**Re: Glendesto Subdivision
Erosion and Sediment Control Plan
Engineer's Stamp Date 10-6-17 (B18E020)**

Based upon the information provided in your submittal received 10-13-17, the above referenced plan is not approved to be included in the SWPPP or to be included in the Work Order construction plans until the following comments are addressed:

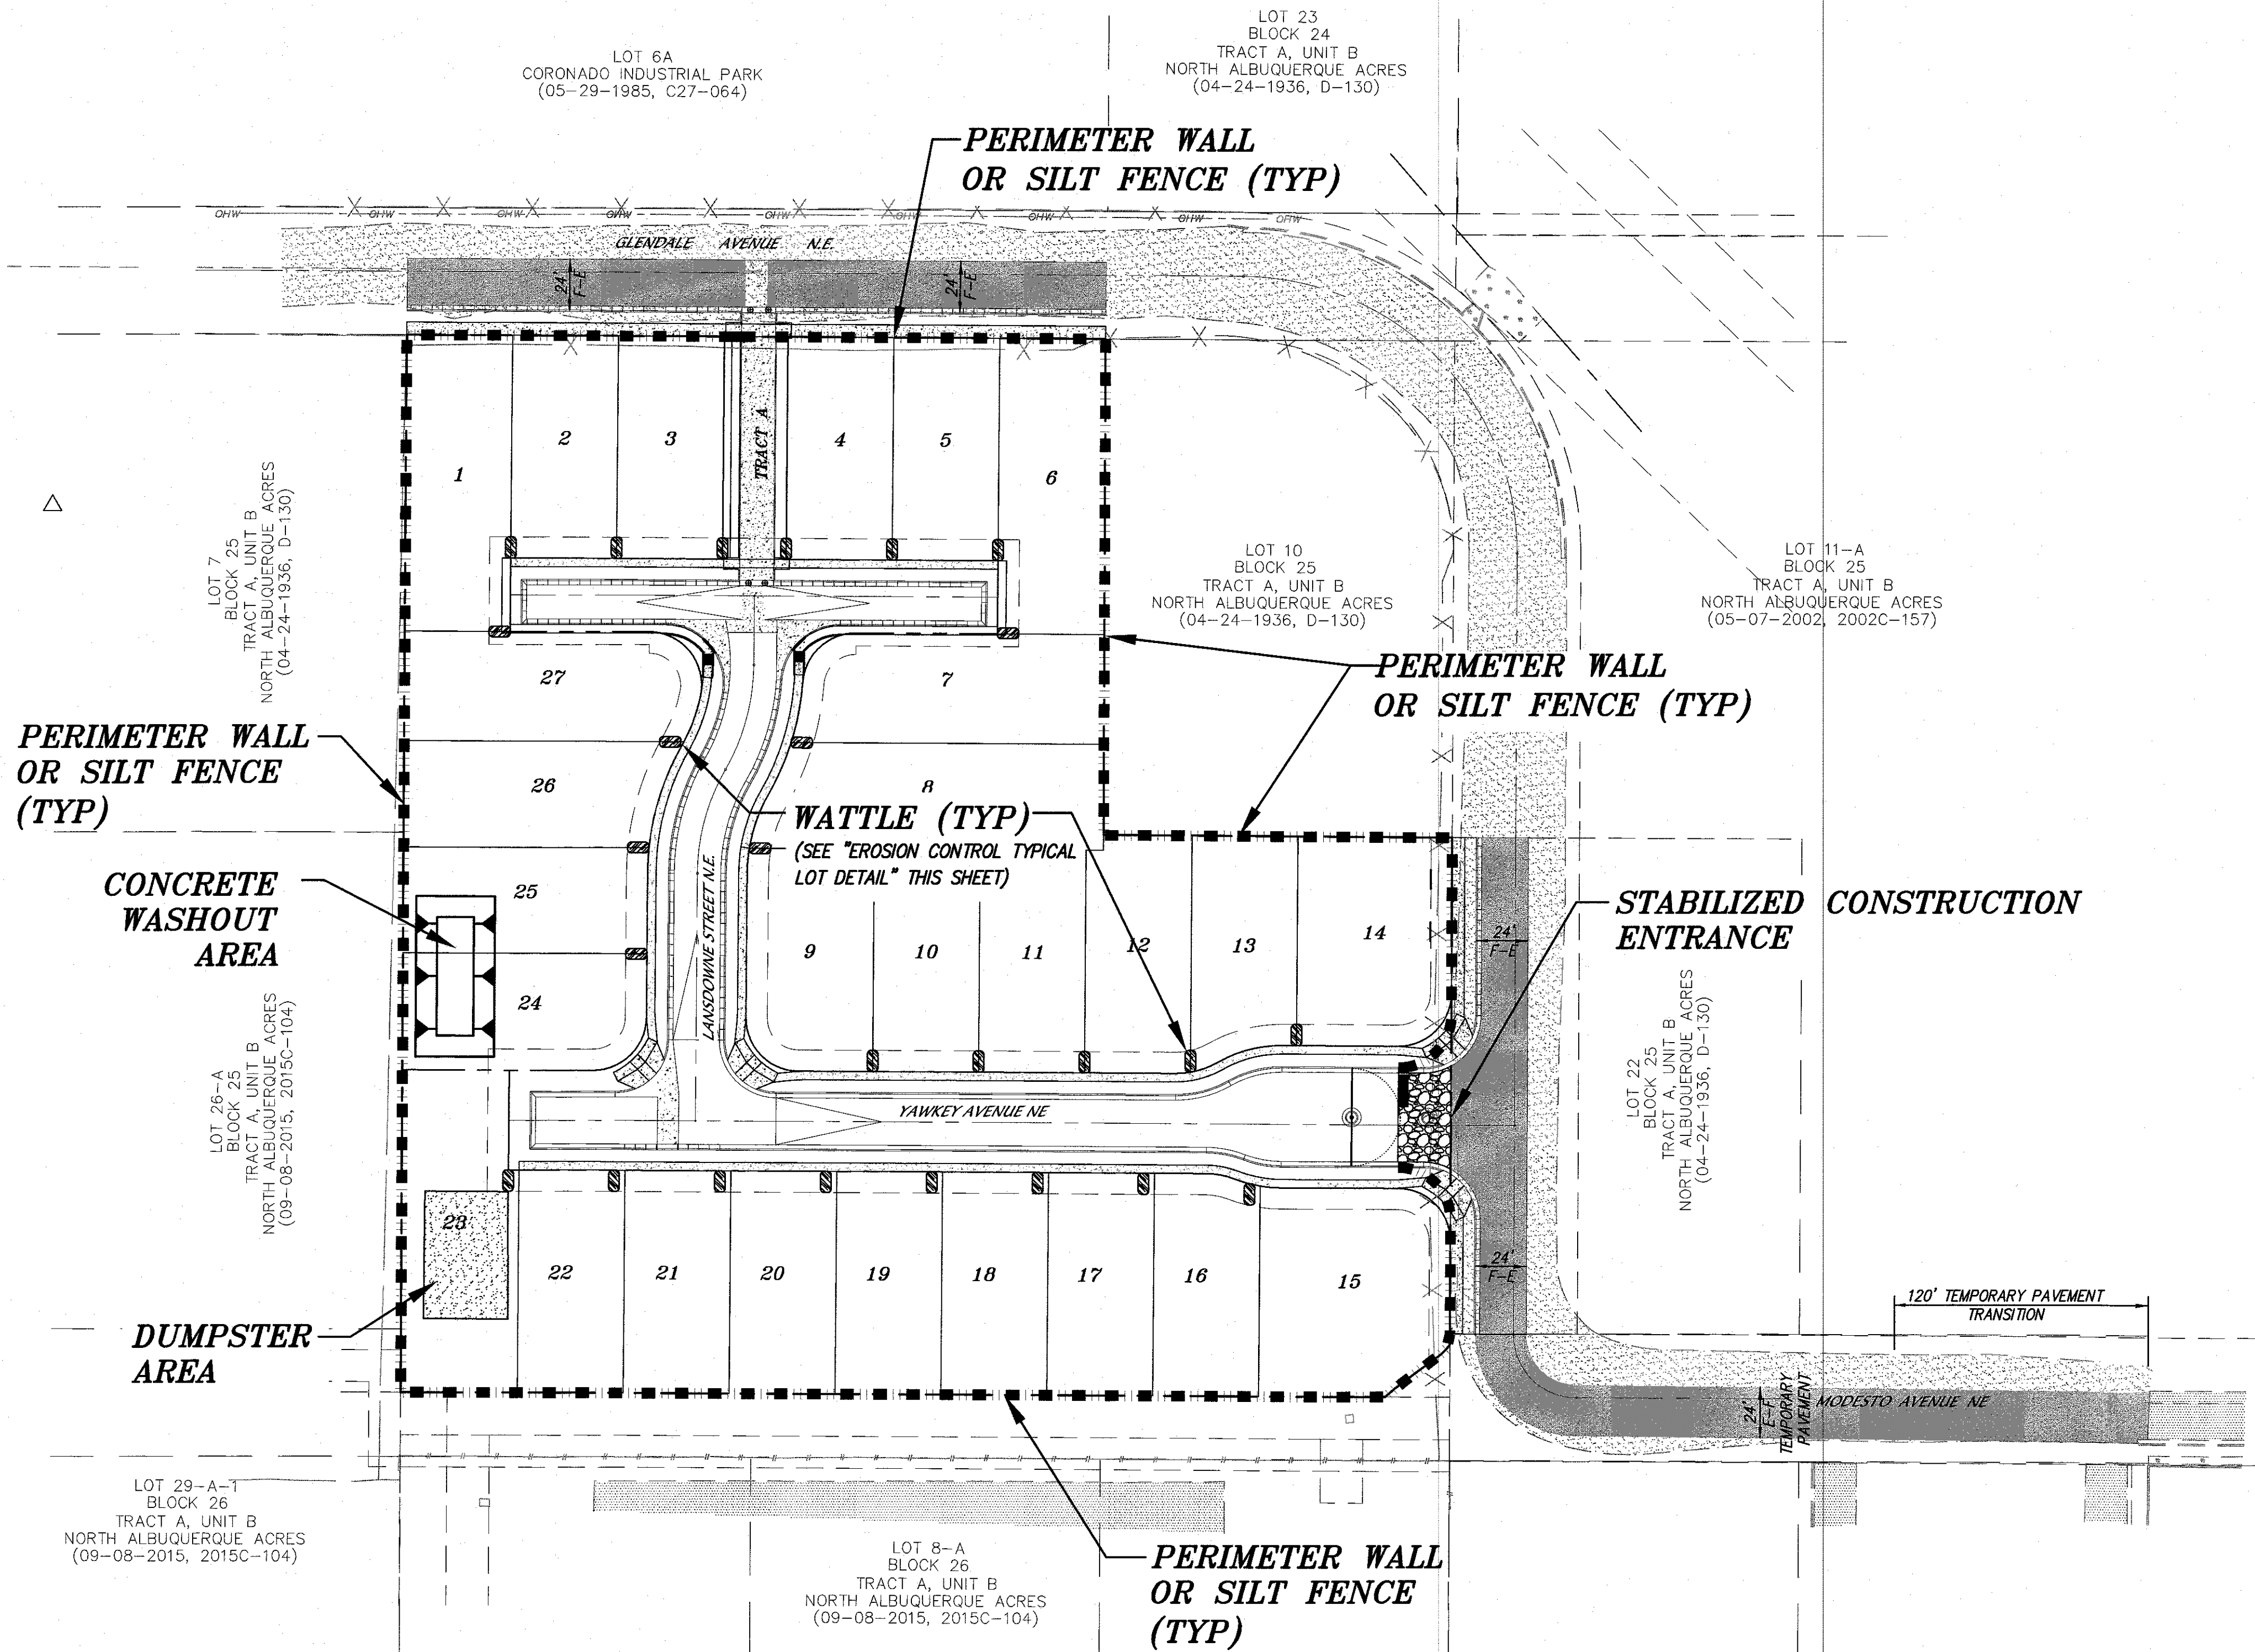
1. Silt fence cannot be installed in the middle of San Pedro due to the surface being asphalt and due to the crown in the road it does not seem necessary. If dirt is present in the southbound lane it can be swept/removed.

The spoils pile from the trenching on San Pedro Blvd should be piled on the east side of the road.

2. Since this section of San Pedro drains north, please provide inlet protection around the inlet at the north end of the project. Inlet protection could be installed on the west, north and south sides leaving the inlet open for flows from the east.

3. For the waterline work at San Pedro a sediment BMP (e.g. filter/mulch sock) should be placed on the south side of Glendale Ave. on the west side of San Pedro Blvd.

4. Since Glendale Ave. will most likely have a full closure, a sediment BMP (e.g. filter/mulch sock) should be placed at the west end of Glendale Ave on the east side of San Pedro Blvd leaving an opening in the middle for construction vehicles.

If there is track-out onto San Pedro, a stabilized construction entrance could be placed in this location.

5. Due to number 4 above, the silt fence shown in the middle of Glendale Ave. can be omitted.

6. Wattles should be replaced with filter/mulch socks in the channel on the north side of Glendale Ave and at the inlet in Glendale Ave. as wattles do not allow drainage to flow through and in general are an erosion BMP not a sediment BMP.

7. As a suggestion, the silt fence across Glendale Ave and Modesto Ave could be replaced with a filter/mulch sock at the west terminus(s) of the disturbed areas, since filter socks can be more easily moved and silt fences have to be trenched-in.

8. The wattle at the north end of Tract A should be replaced with a filter/ mulch sock as this is a drainage way.

9. Provide grades.

10. Provide a detail for filter/mulch sock and wattle installation(s).
